From: Simon Davis
Sent: 03 January 2018 12:21
To: Planning Scanning
Subject: FW: AL/129/17 Forge House
Attachments: Existing Plan with annotated wall to be removed.png

From: Simon Davis
Sent: 03 January 2018 12:21
To: 'Susan Leeson'
Cc: Richard Vickery
Subject: RE: AL/129/17 Forge House

Sent: 02 January 2018 09:31
To: Simon Davis
Cc: Richard Vickery
Subject: AL/129/17 Forge House

Location and Site Plans

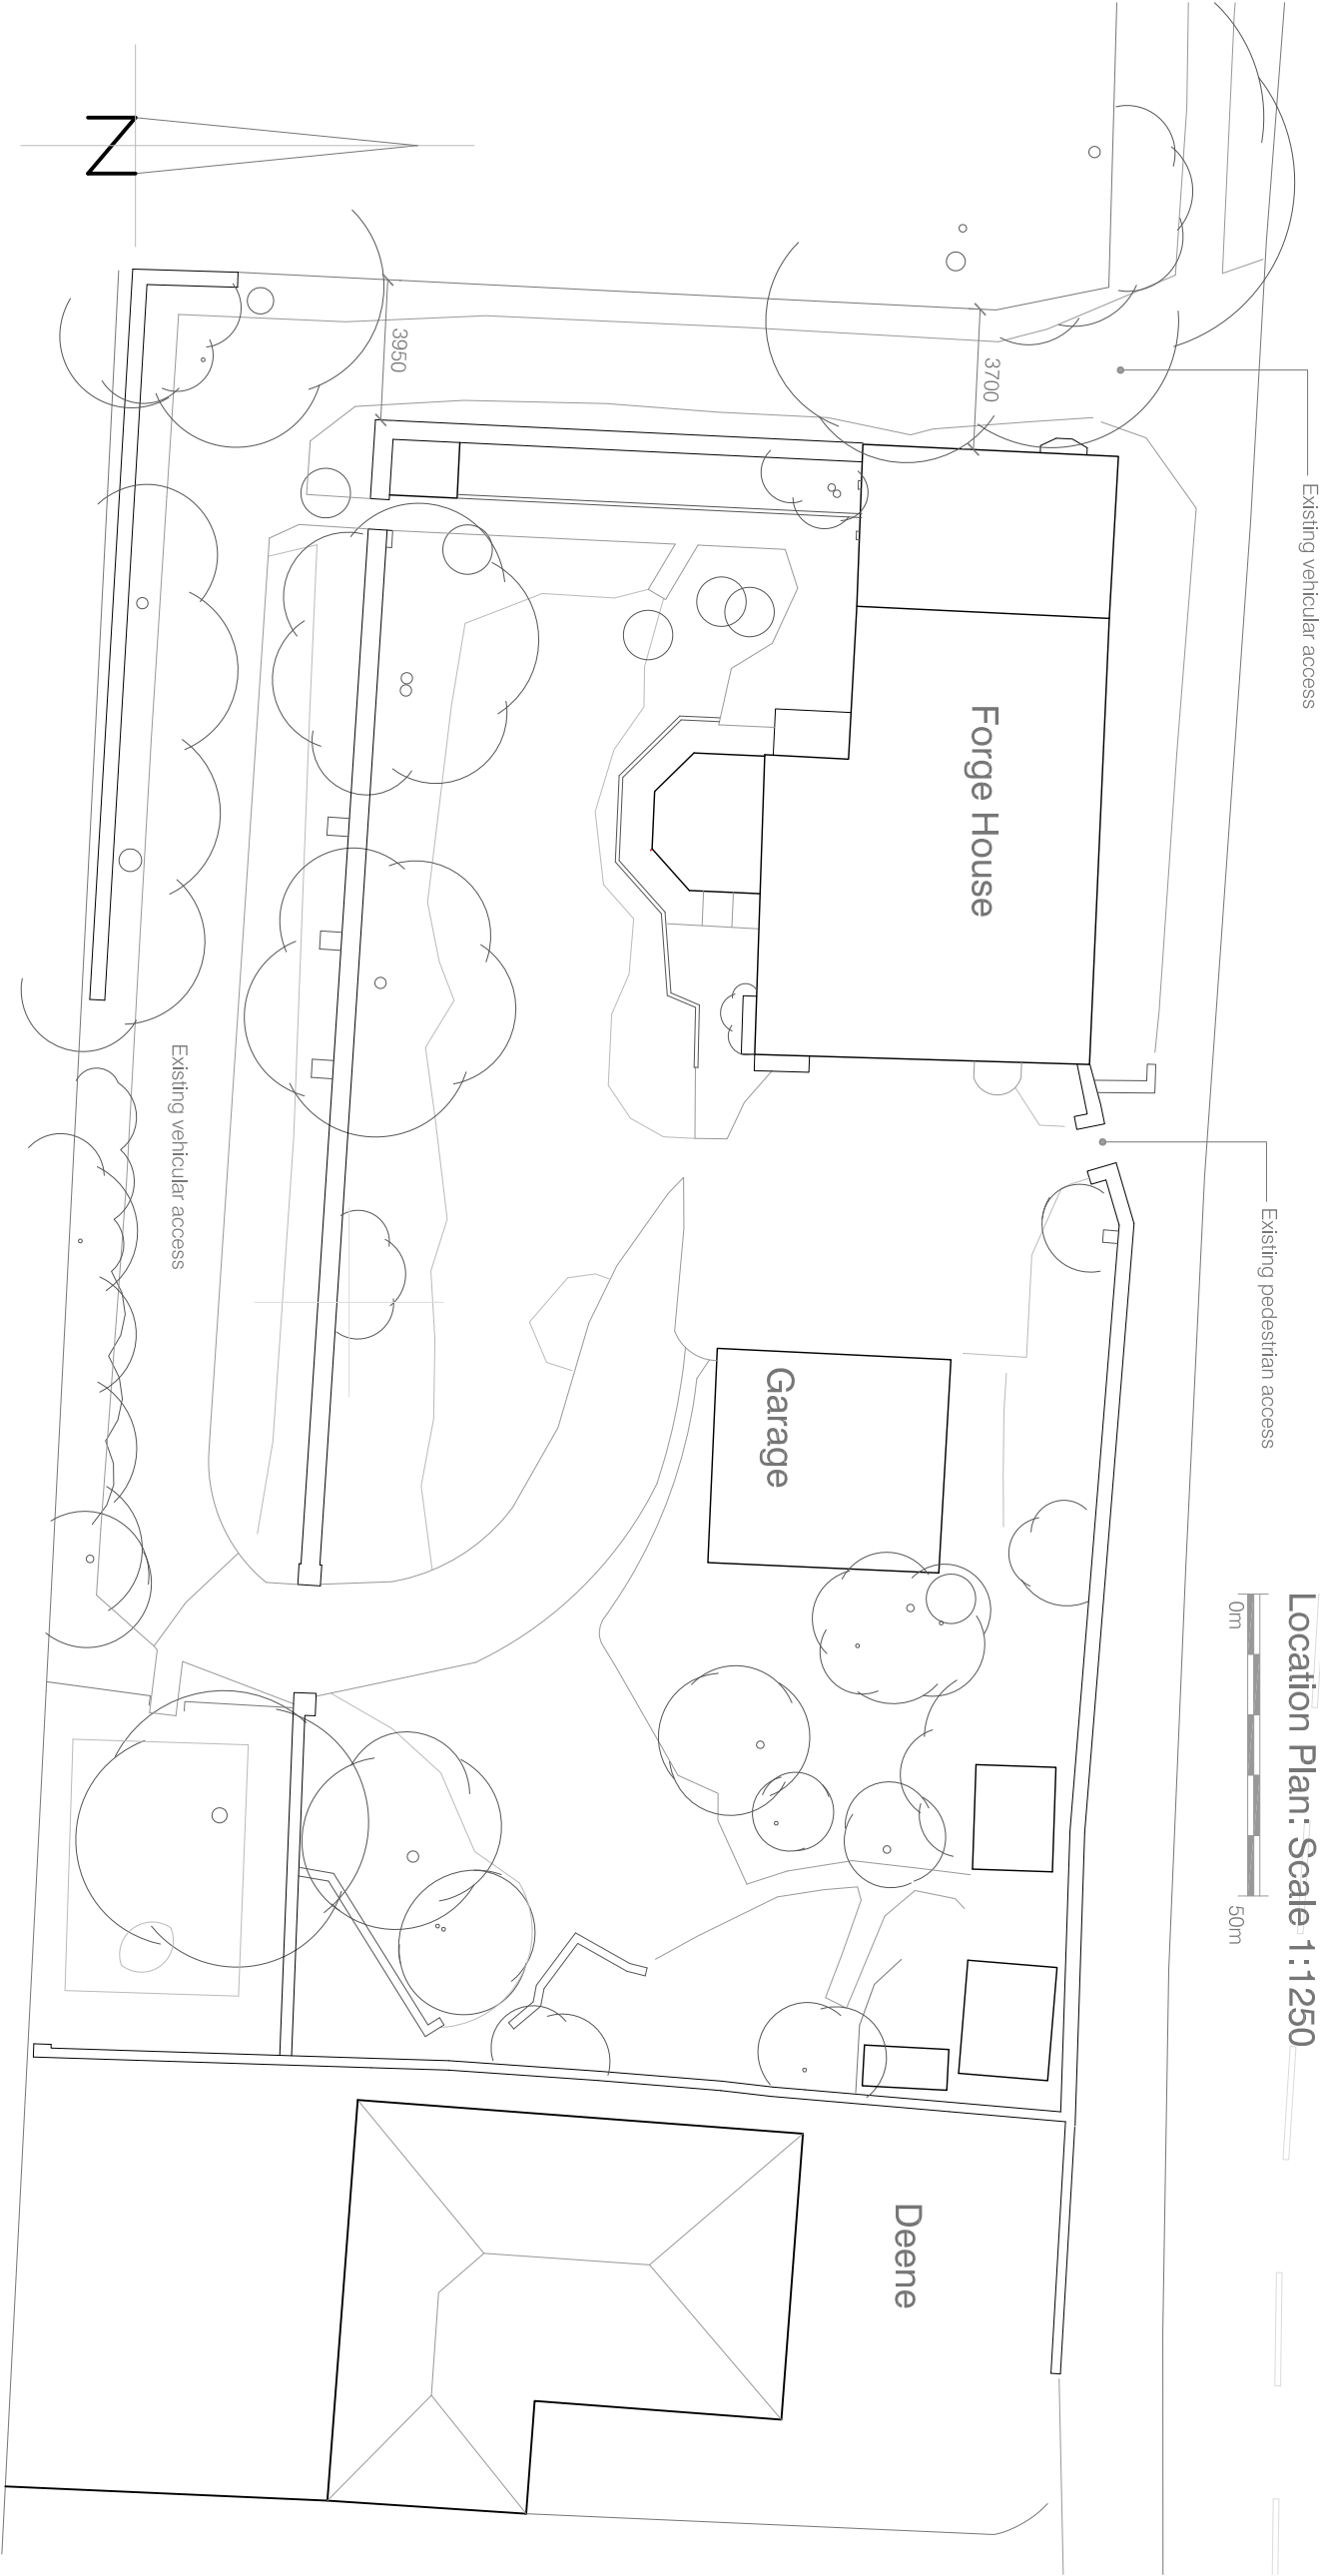
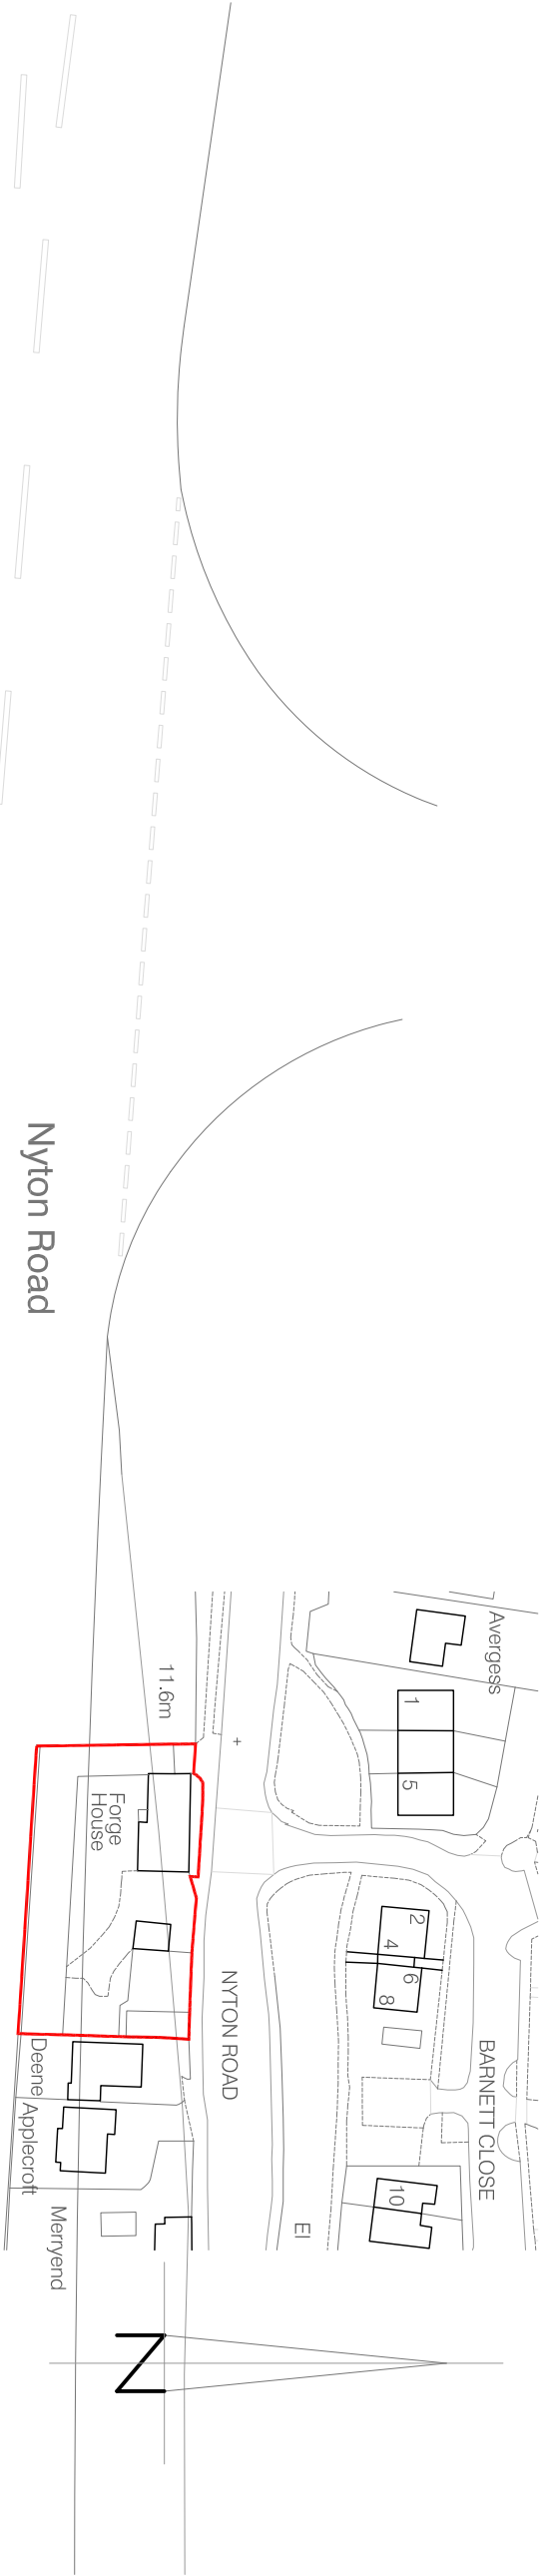
The Conservation Officer was referring to the removal of the wall which is within the site. I have annotated an existing site plan to indicate which wall she is referring to.

I have read the comments from the Conservation Design Officer and it is factually incorrect. It states, "*the proposals detail removal of 24 linear metres of walling to create vehicular access*". The access is existing and no new vehicular access is proposed.
